Dogger Bank South Offshore Wind Farm

Appendix F5 to the Natural England Deadline 5 Submission
Natural England's comments and updated advice on Marine Mammals

Planning Inspectorate Reference EN010125

23rd May 2025

- Legend:
- Offshore Development Area
 - DBS East Array Area
 - DBS West Array Area
 - Berwickshire and North Northumberland Coast SAC
 - DBS West Mitigated (-10dB) Unwtd SELss 5dB increments
 - DBS West Unmitigated Unwtd SELss 5dB increments

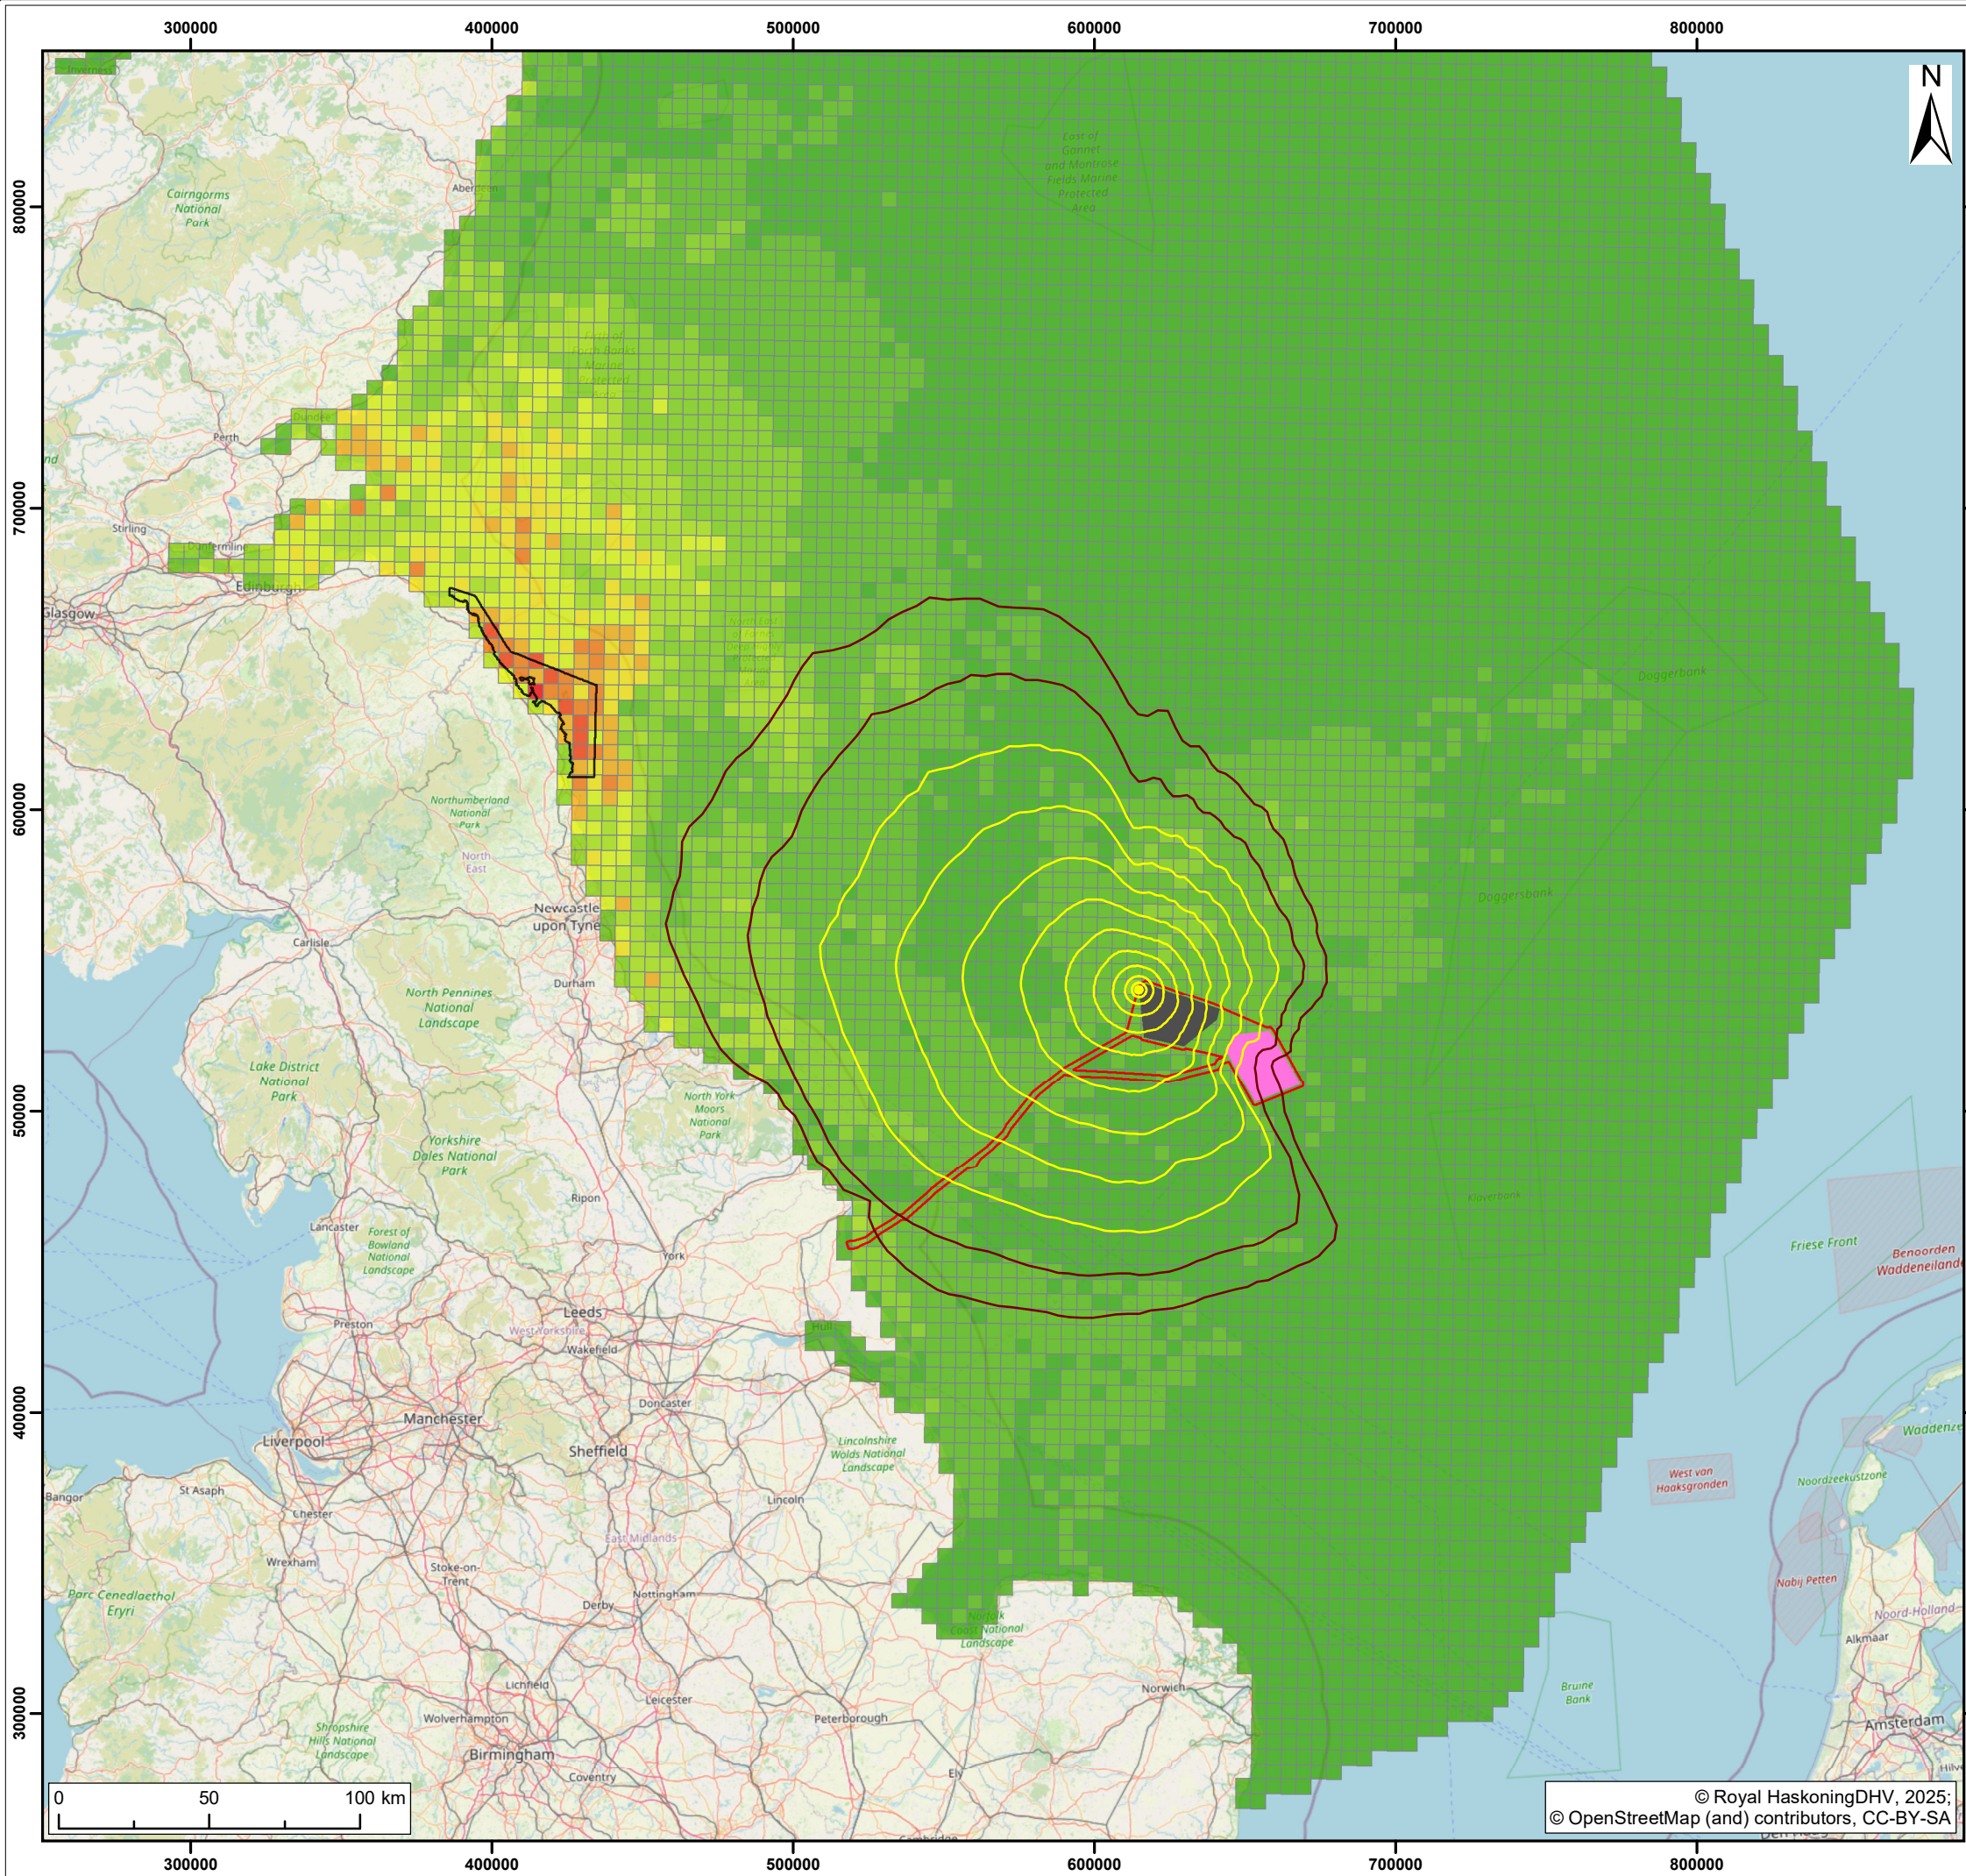
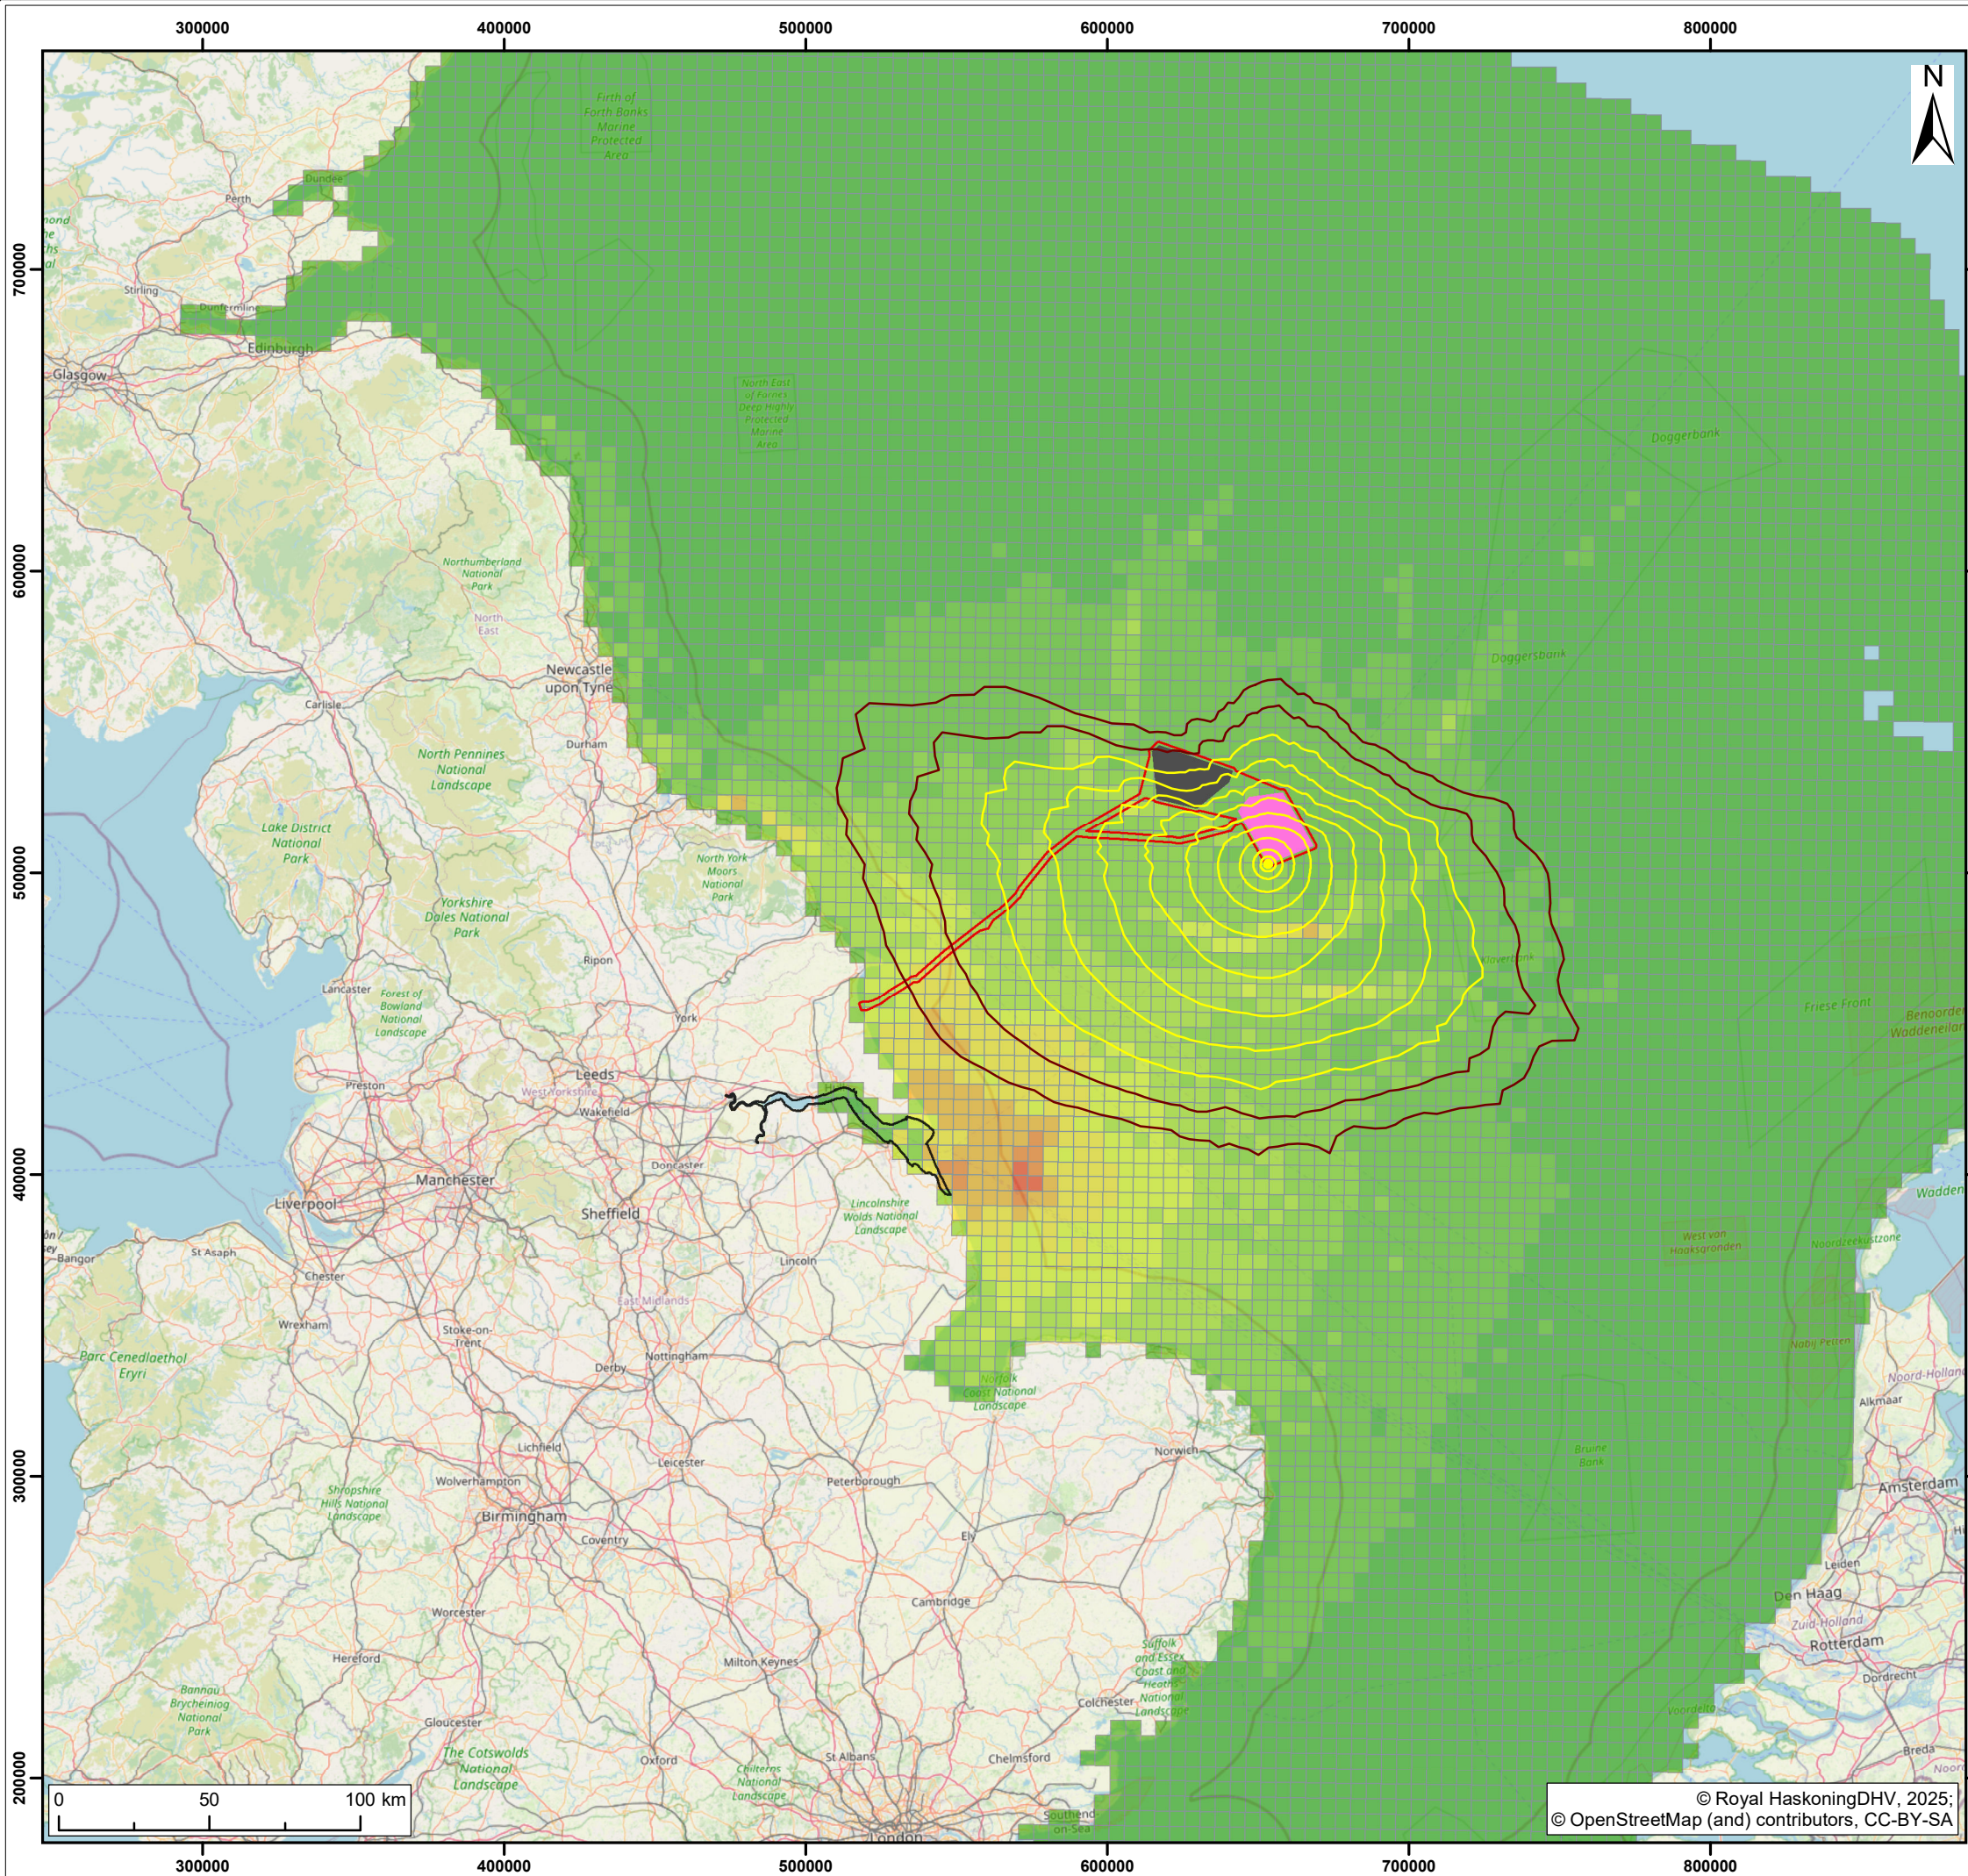
[REP4-094] demonstrates that if a 10 dB reduction in underwater noise (UWN) was achieved through primary or secondary mitigation, impacts to marine mammal species would be significantly reduced. The reductions presented would likely remove the significant impacts on marine mammal populations currently predicted and enable Adverse Effects on Integrity (AEoI) of the Humber Estuary SAC, Berwickshire and North Northumberland SAC and Southern North Sea SAC to be ruled out. They would also reduce the injury zones for minke whale and harbour porpoise to a level that could be fully mitigated with Acoustic Deterrent Devices. This is all welcome, however the Applicant also states that they “*will not be committing to any specific secondary noise reduction methods until the final design parameters, including all relevant primary measures, are finalised post consent*”. Natural England accepts this and does not expect the Applicant to commit to specific secondary noise reduction methods. Instead, we suggest that the Applicant could commit to achieving a 10dB reduction in UWN during construction from levels predicted in the environmental assessment via primary and/or secondary mitigation, with the exact systems and/or technologies to be determined post-consent. **We consider a commitment of this nature to be essential, as unsecured mitigation that may or may not be applied cannot be considered in impact**

assessments. We must therefore base our conclusions on the assessment as it currently stands, whereby our position remains that AEol cannot be ruled out for grey seals in the Humber Estuary SAC for the project in-combination with other plans and projects, for grey seals in Berwickshire and North Northumberland Coast (BNNC) SAC for the project alone, and harbour porpoise in Southern North Sea SAC in-combination with other plans and projects.

As impacts cannot be ruled out at this time, particularly for the Project alone and injury zones, it is not in doubt that additional mitigation will be needed post-consent. Further, as the Applicant considers that a (minimum) 10dB reduction is both achievable and necessary to reduce impacts, we do not consider that it is unreasonable to expect the Applicant to commit to additional mitigation at this stage. We also highlight that commitments of this nature are not without precedent. During the Rampion 2 OWF Examination, the Applicant committed to a 15dB reduction through the use of NAS to reduce UWN impacts on black seabream in the Kingmere MCZ.
